RE: Steed/Frexes Residence
Peaks Island, Maine

Please find attached my redline structural comments addressing the conditions exposed to view during the demolition phase of the kitchen renovation / first floor stabilization at the Steed/Frexes Residence on Peaks Island. I am glad to visit the site again during construction if you or the contractor wish.

FIRST FLOOR
FRAMING
& FOUNDATION

**Proposed First  
Floor Plan**

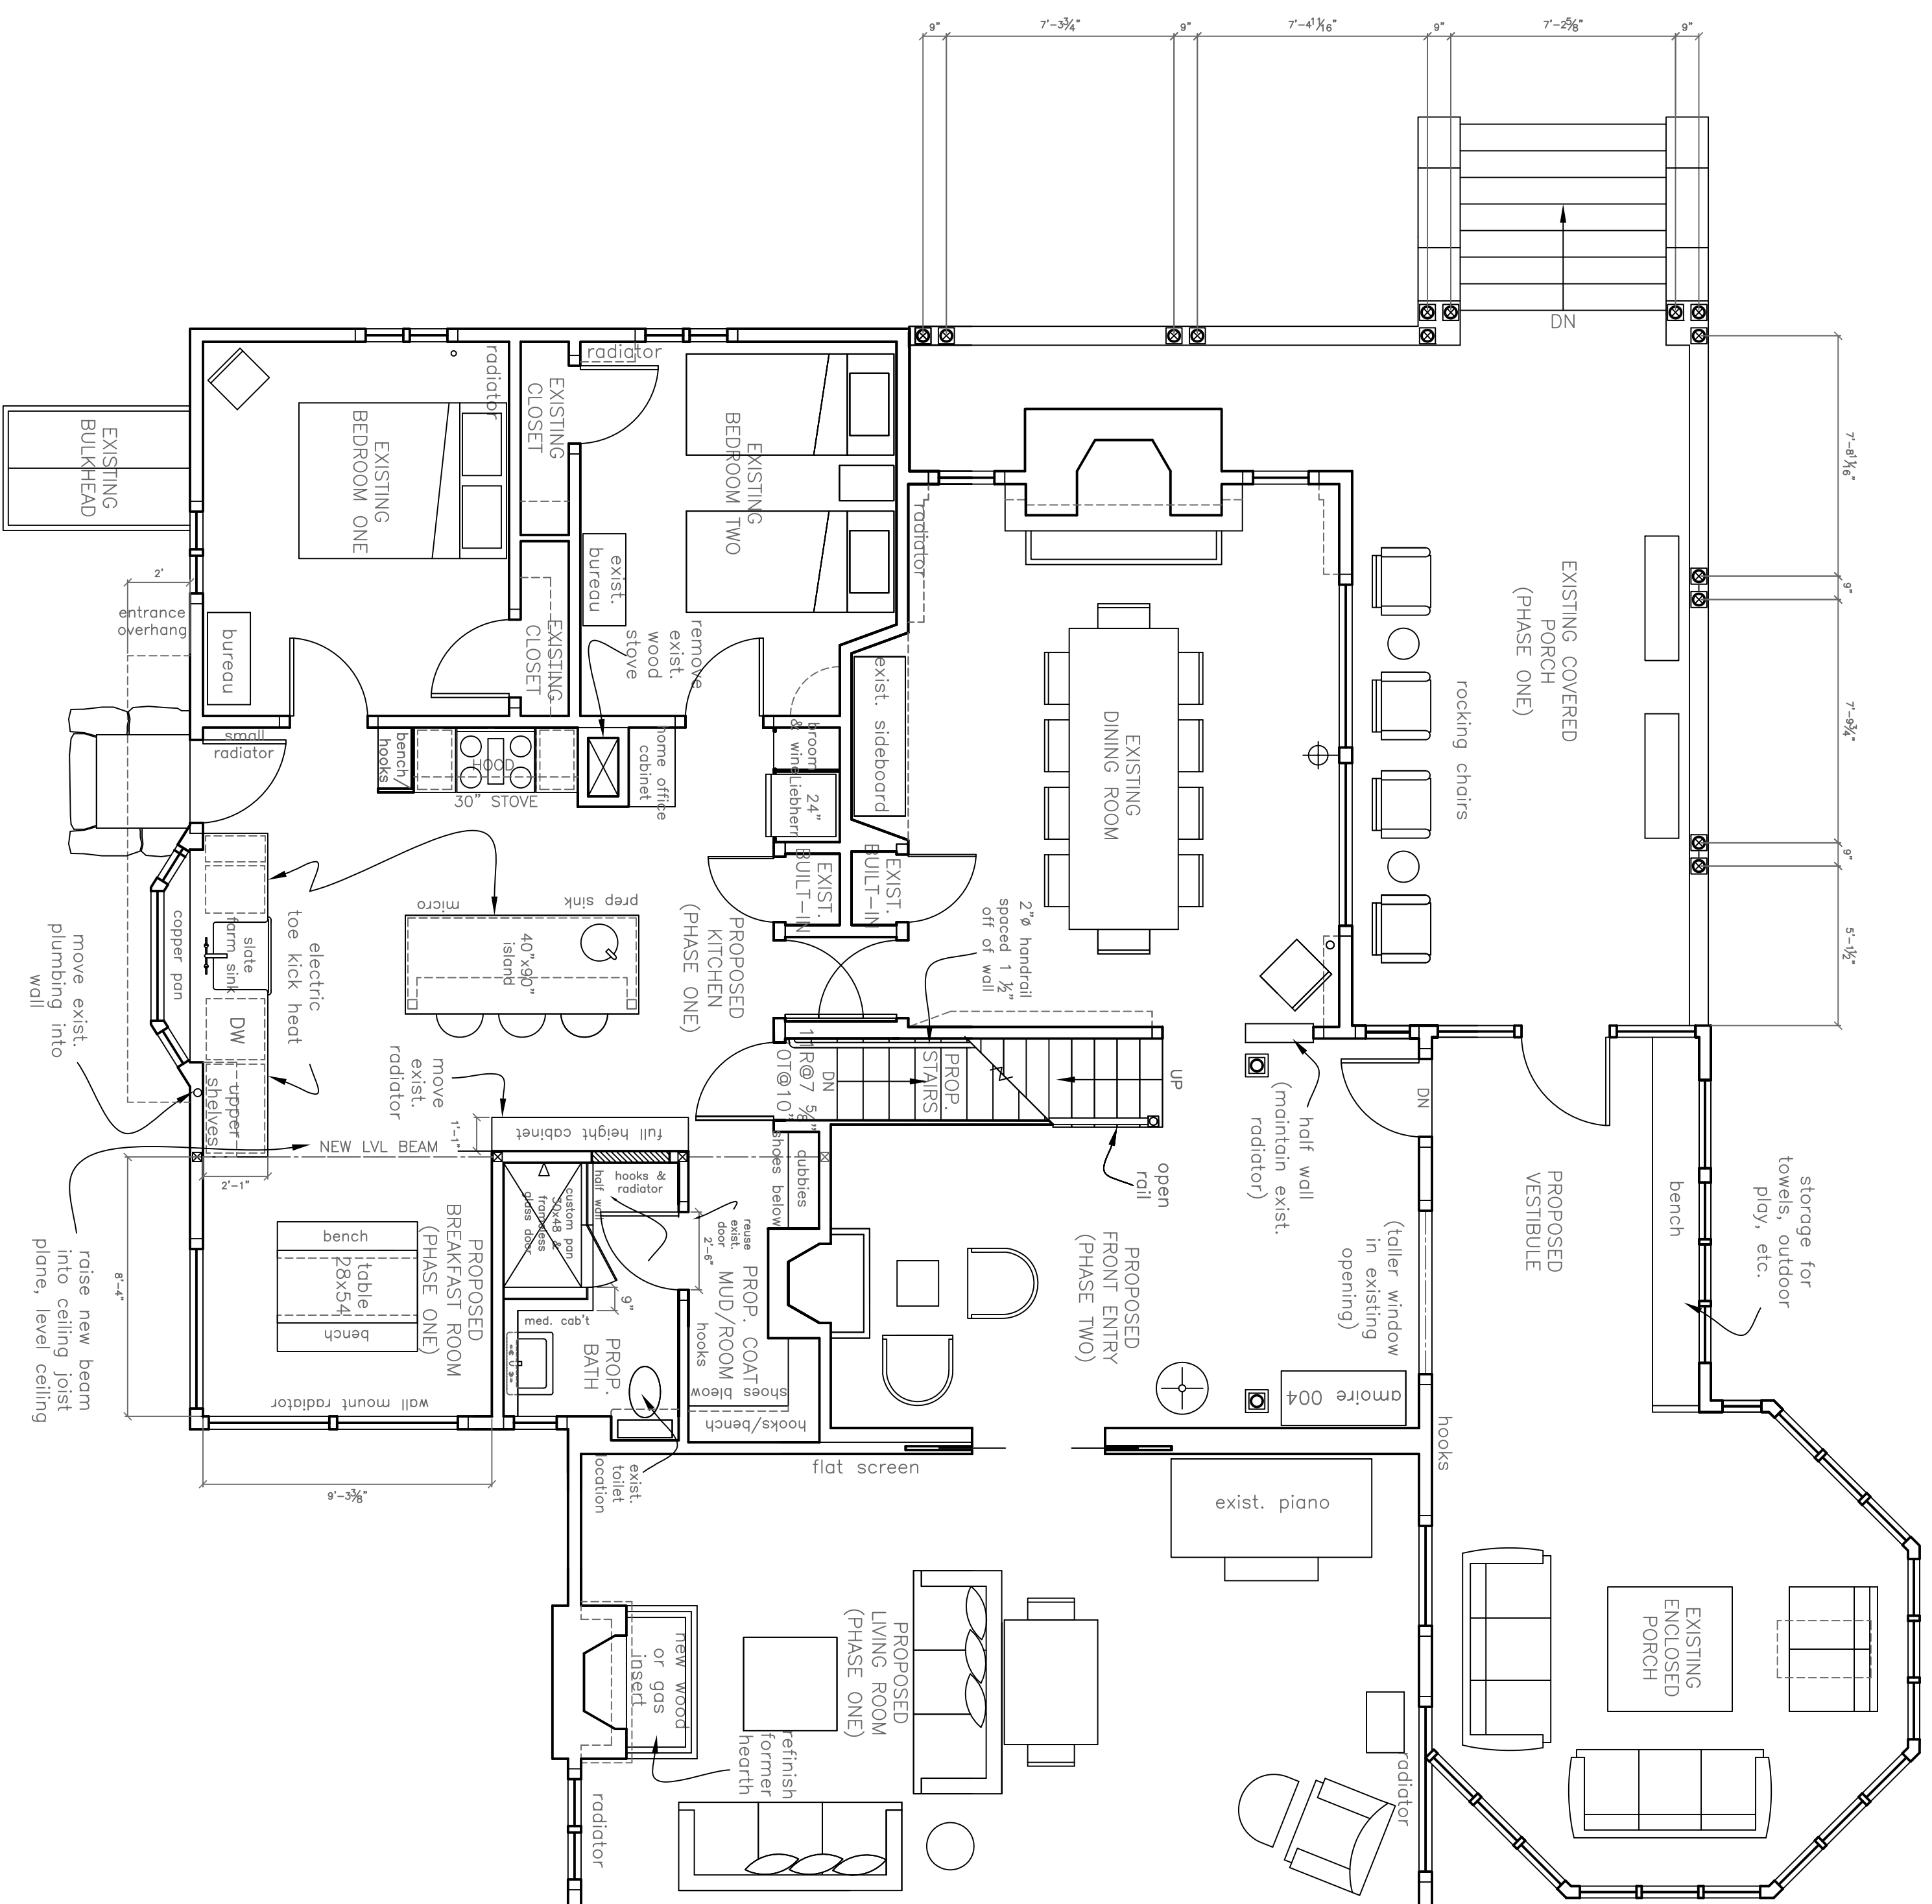
10' floor (42+15)
5' floor (40+20)
7' floor (30+10)
60 post walls
2' post
803
M = 10.6
I_{eq} @ 3/8" = 256
I_{eq} @ 1/2" = 387
ASSUME 5 1/2" LVL
7 x 5 1/2" I = 97
387 x 2 x 10 = 774
774 = 2 x 97 = 580 = EI_{beam}
E = 29 x 10⁴
I = 20
2 PL h = 5 1/2"
10 = bh³/12 → b = 0.72"
2-PL 1/2" x 5 1/2" 4-1 3/4" x 5 1/2" LVL
STRENGTH OK. ✓ Δ = 0.33"

ML6 x 15.3

BEAM B

ML6 x 15.3
1-1 3/4 x 5 1/2 LVL
1/2" bolts staggered at
16" or 3 1/2 x 5 1/2 LVL
post each end

3.5' (30 x 0.76 + 10) =
9.5' (38 x 0.76 + 10) =
40 post walls =
520 plf

13.75'
12.3 kft
I_{eq} @ 3/8" = 304 @ 2.0E
I_{eq} @ 1/2" = 3075 psi

SS HEAVY-PIN F_h = 1200
C_d = 0.80 (WID & PACE)
1200 x 1.15 x 0.80 = 1286 psi
I_{eq} = 3075 / 1286 = 2.40

ADD 3 1/2 x 6 LVL EACH SIDE
I = 270

NO MODIFICATIONS,
STRENGTHENING EXISTING
NON-CORRELATING
BEAMS.

stick existing floor joists
with 1 3/4 x 5 1/2 LVL.
shim tight and install
Simpson U44R hangers
at beam B

"BEAM A"
4-1 3/4 x 5 1/2 LVL
2-1 1/2" x 5 1/2" STEEL PL
1/2" bolts staggered at
16" or 4 within 12"
of each end.
